Engineers comments for FG/120/12

APPLICATION FG/120/12/

Site Address: The Old Barn Ferringham Lane Ferring BN12 5LL

Description of Works: Amendments to previous approval FG/6/12/ for change of use of the Old Barn, Annexe building & warehouse from retail (A1 Shops) to 2 no. 3 bed residential dwellings (C3 Dwelling

Car Parking Shelter - Plan & Elevations

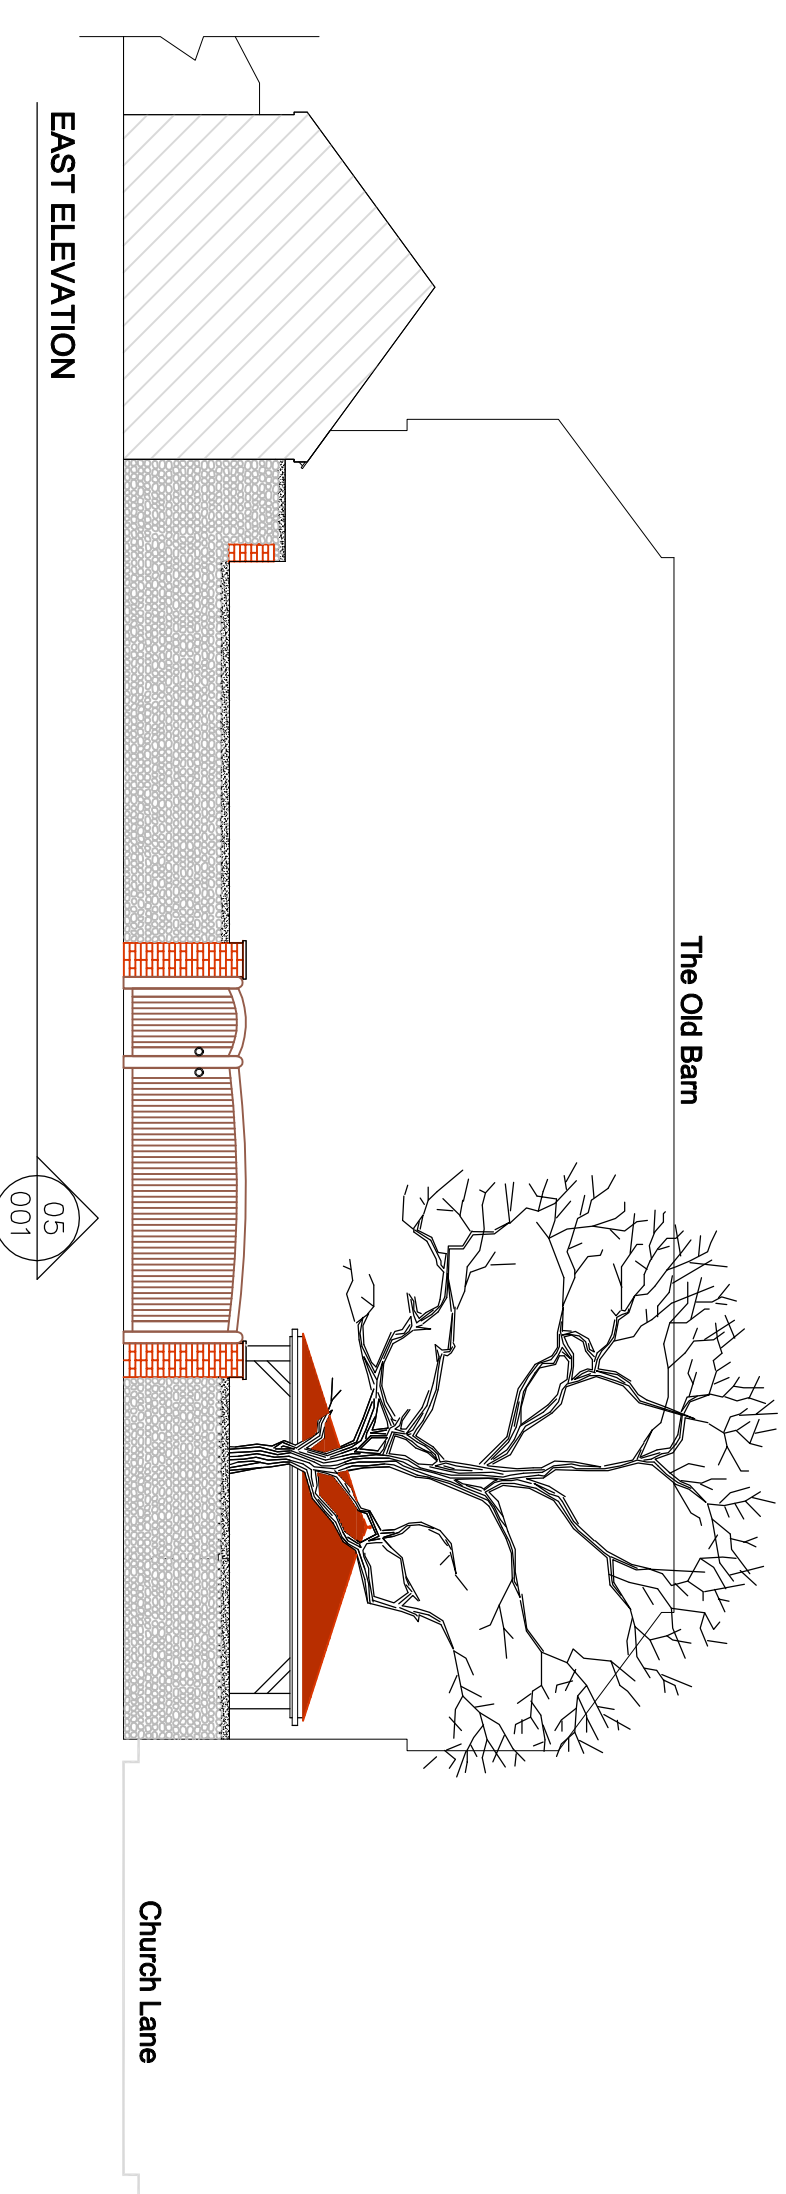
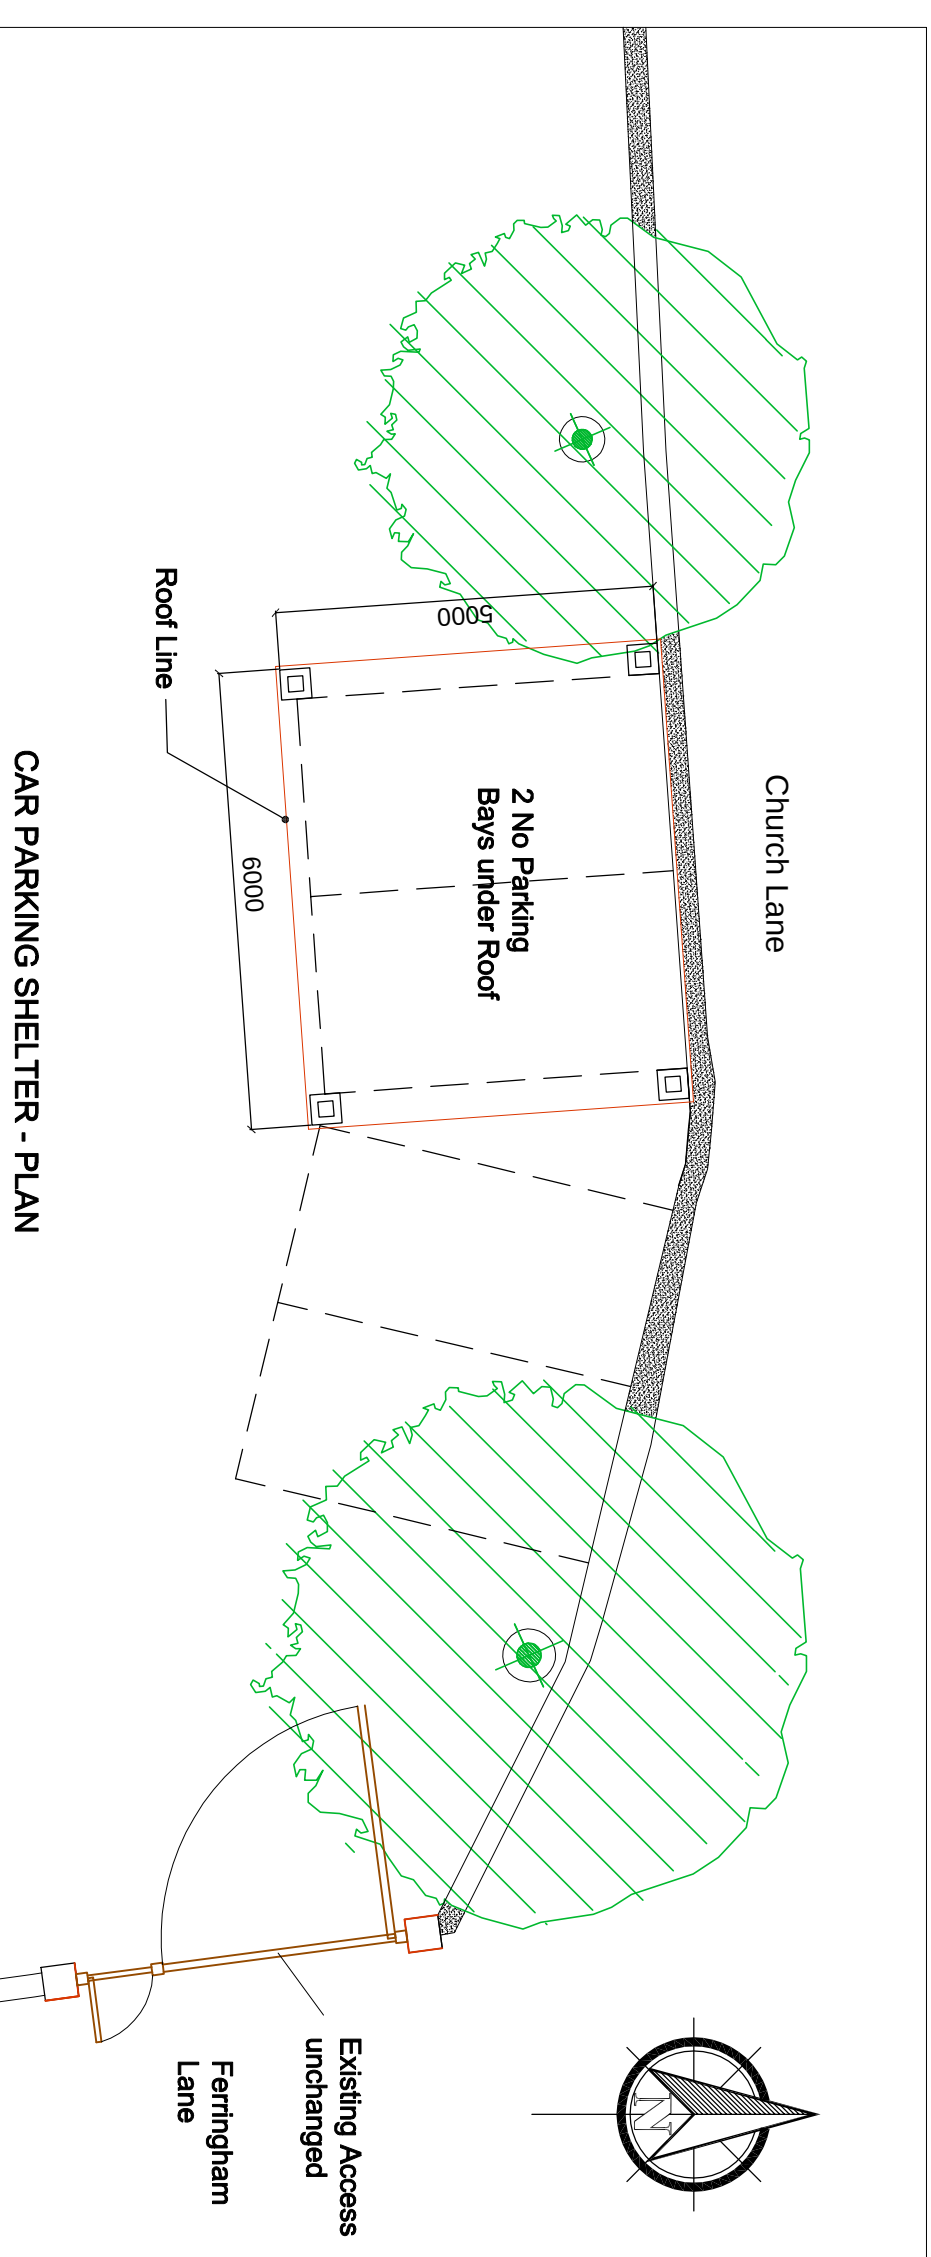
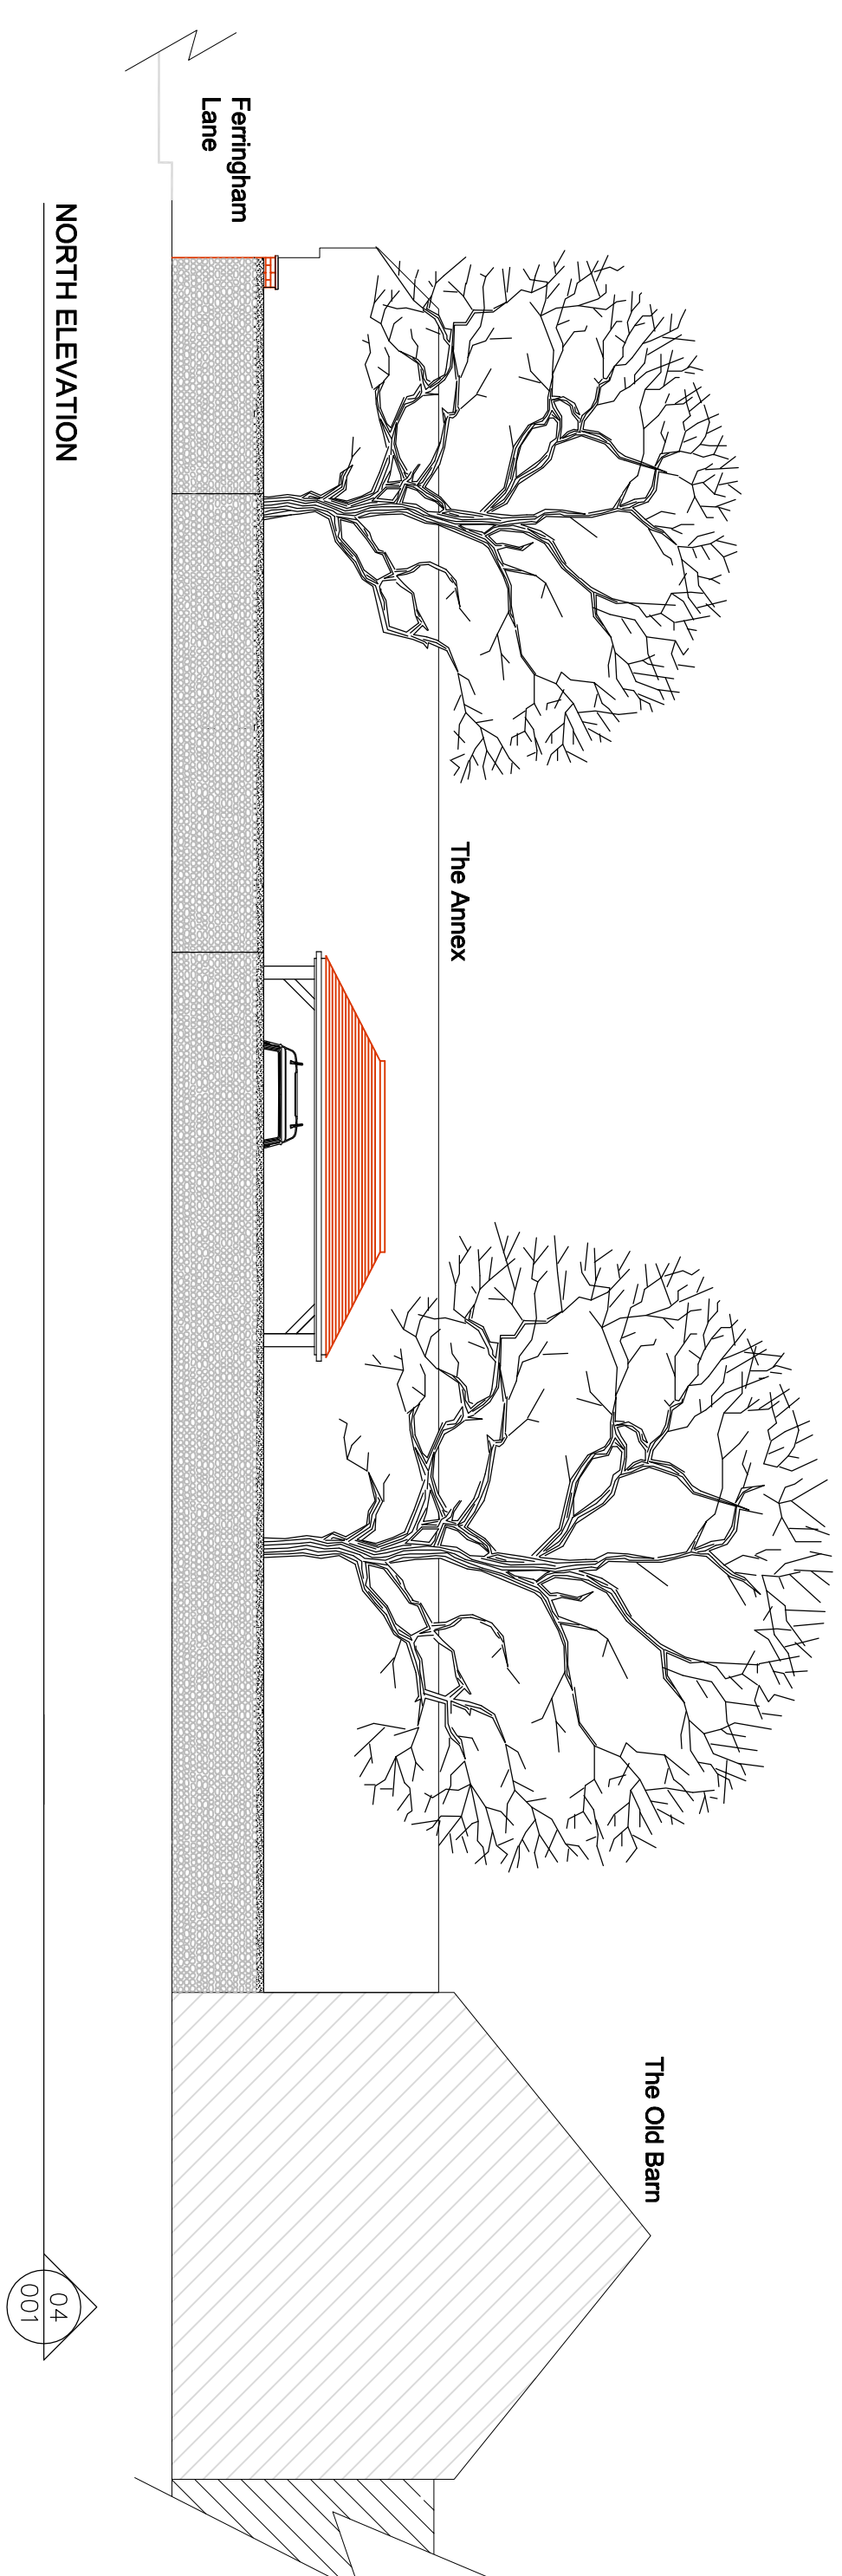
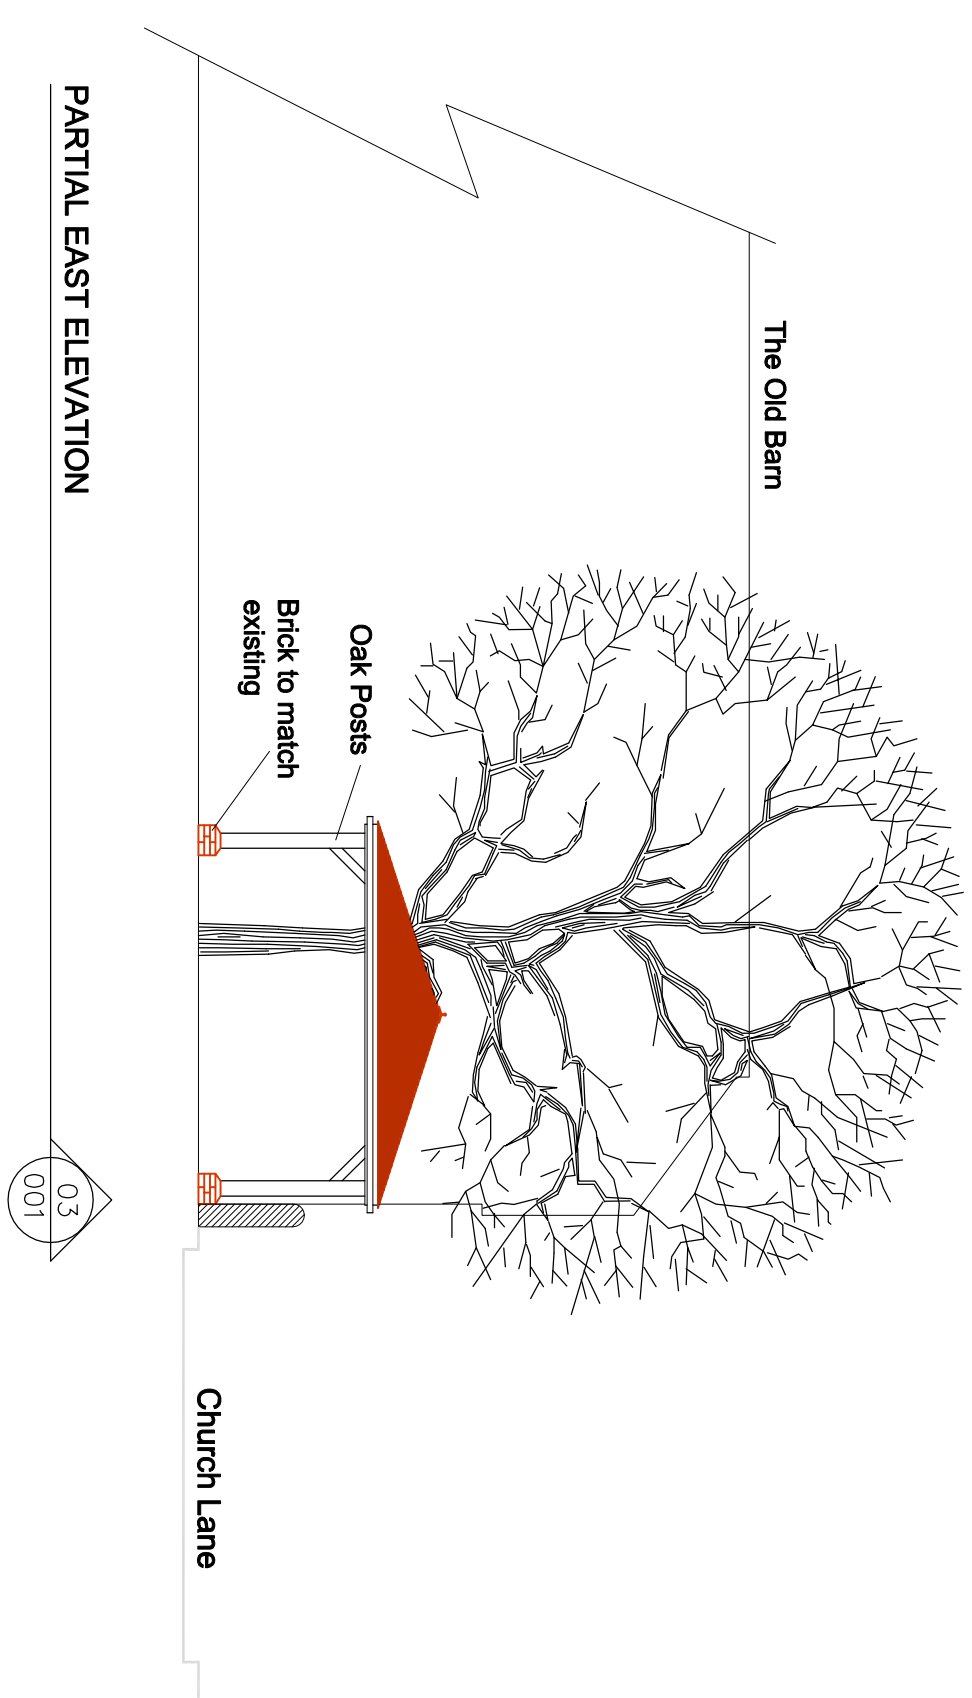
The car shelter will require drainage designs to be submitted please apply the following condition:

Development shall not commence until full details of the proposed surface water drainage scheme for the car shelter have been submitted to and approved in writing by the Local Planning Authority. The design should follow the hierarchy of preference for different types of surface water drainage disposal systems as set out in Approved Document H of the Building Regulations and the SUDS Manual produced by CIRIA. Groundwater monitoring to establish highest annual ground water levels and Percolation testing to BRE 365, or similar approved, will be required to support the design of any Infiltration drainage.
